GREATER WESTERN  
AREA HEALTH SERVICE  
NSW HEALTH

The Greater Western Area Health Service is pleased to have the opportunity to provide comment on the Environmental Assessment report for the Rasp project (Application 07\_0018)

# **Greater Western AHS Submission - Rasp Mine Project**

## **August 2010**

Figure 3: Free Areas of the Site

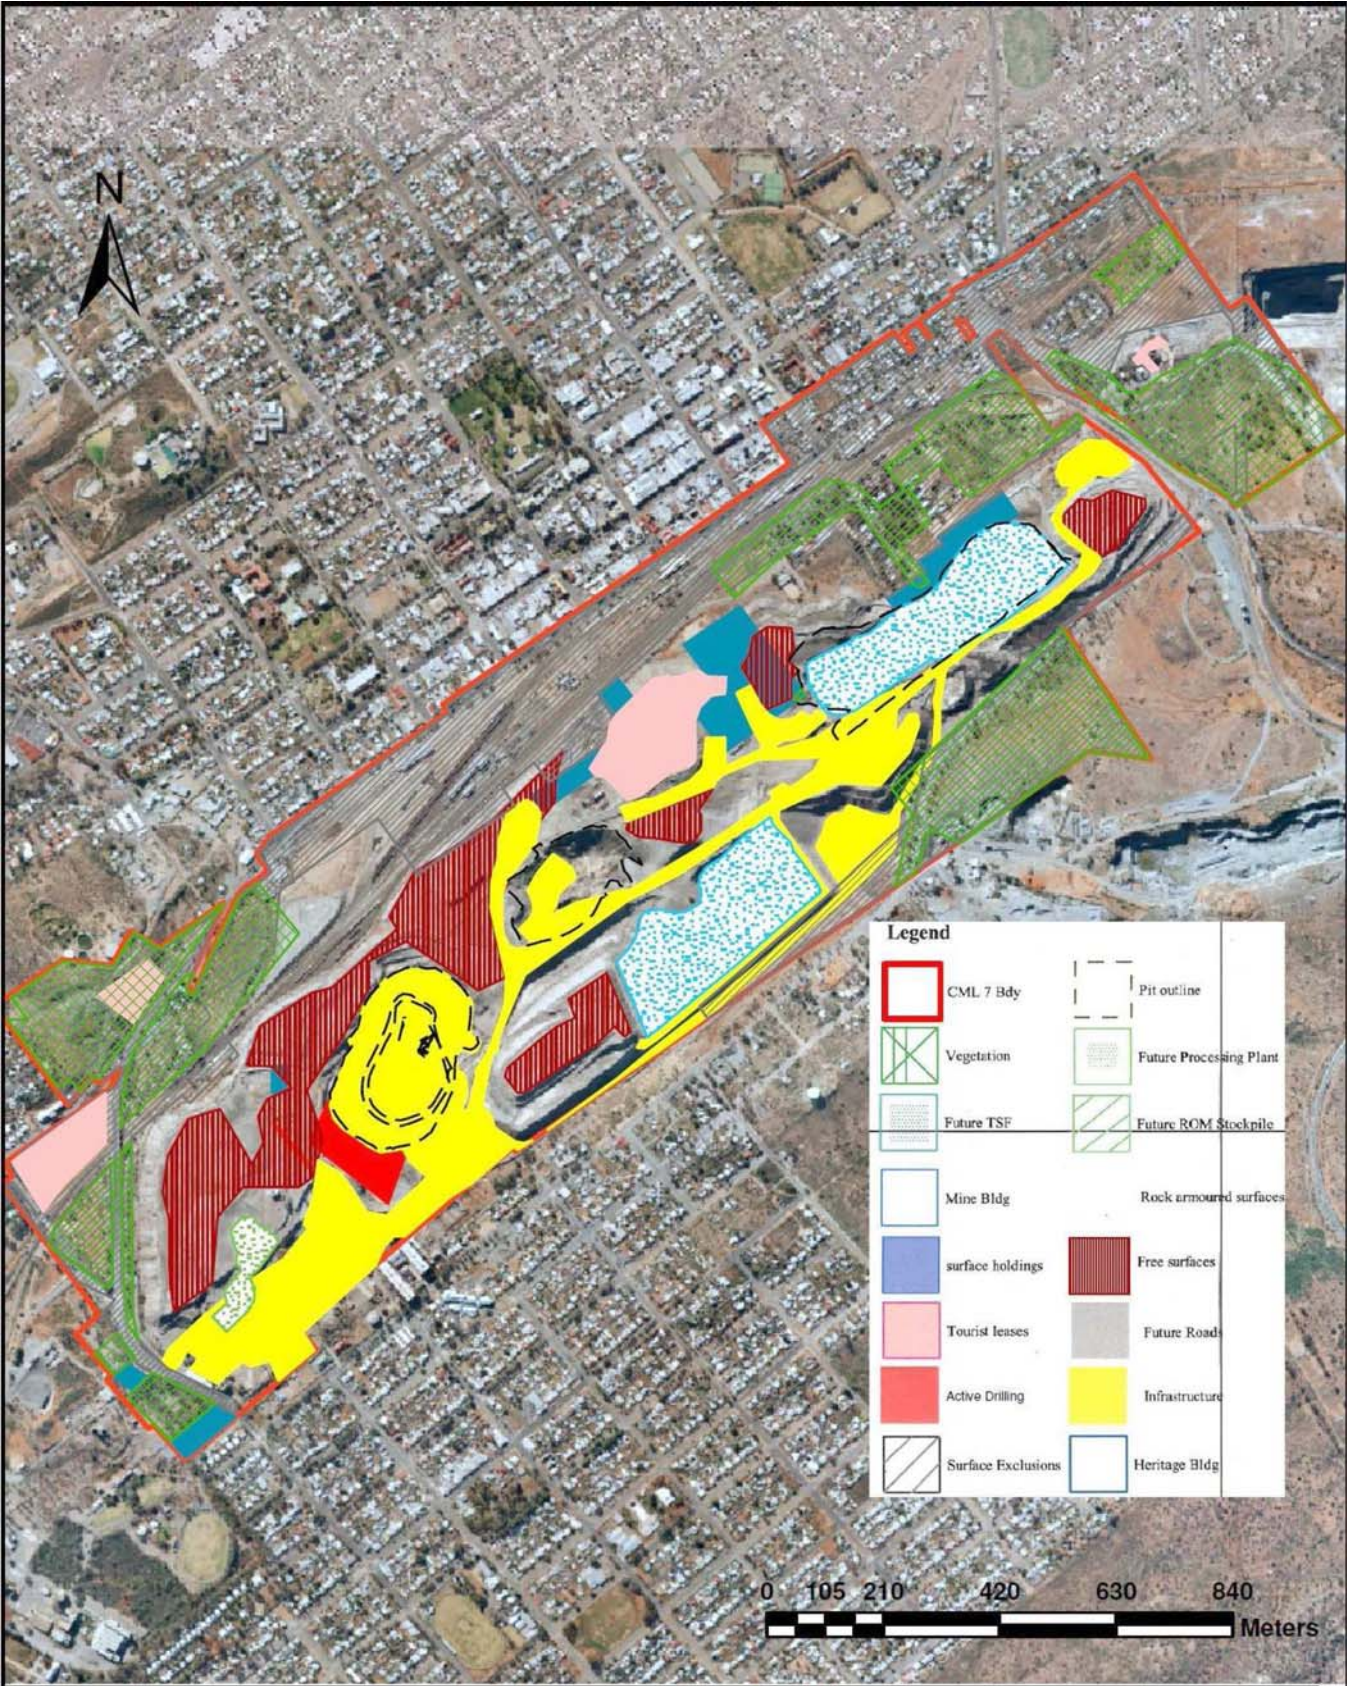
Also of particular concern is the potential for increased dust emissions from tailings dam and fugitive dust emissions from free areas on the site. Active surveillance and reactive management of the emissions from the tailing dam must be instituted.
